From: Jeff Robertson <[REDACTED]>
Sent: 23 March 2020 16:23
To: Nicola Moore
Subject: RE: 75 Mead Lane, Bognor Regis, PO22 8AP

From: Jeff Robertson <arun@arun.gov.uk>
Sent: 16 March 2020 14:46
To: Nicola Moore <Nicola.Moore@arun.gov.uk>
Subject: 75 Mead Lane, Bognor Regis, PO22 8AP

FIRST FLOOR PLAN

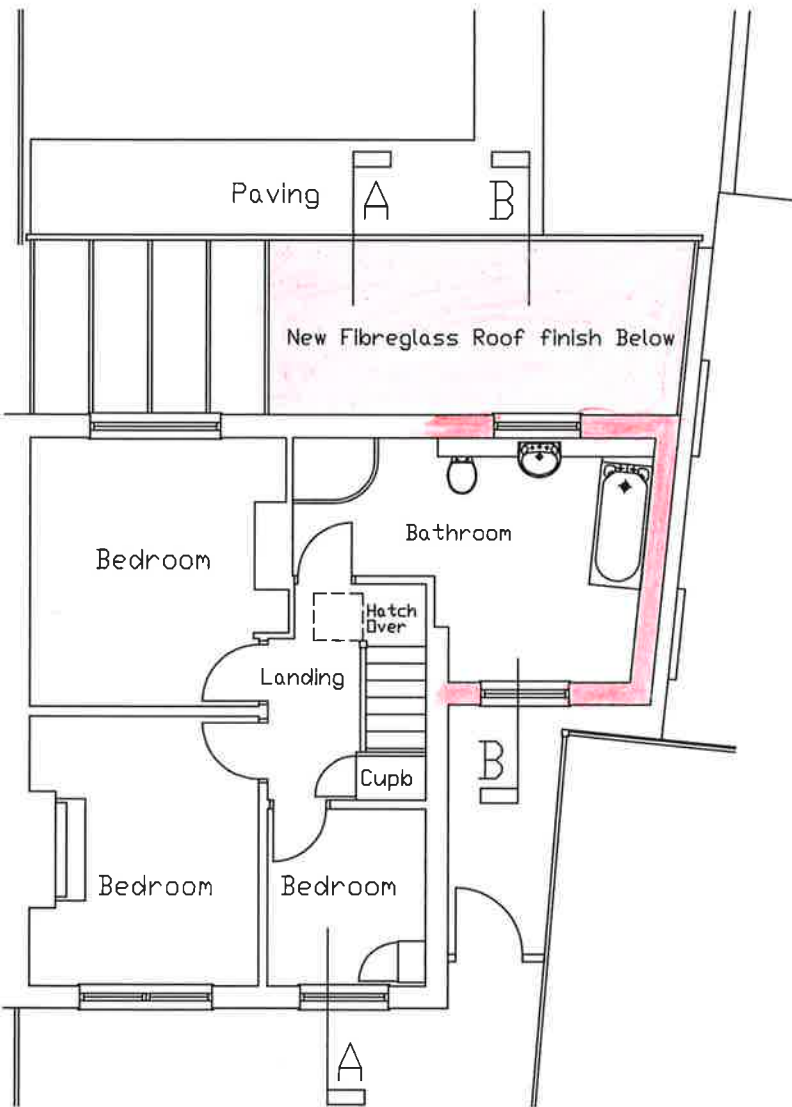
For clarity, please can you confirm if the door that is shown on the proposed first floor plan is a door or a side access at ground level.

I confirm that the door shown on the first floor plan is the existing gate at ground floor level which is unchanged.
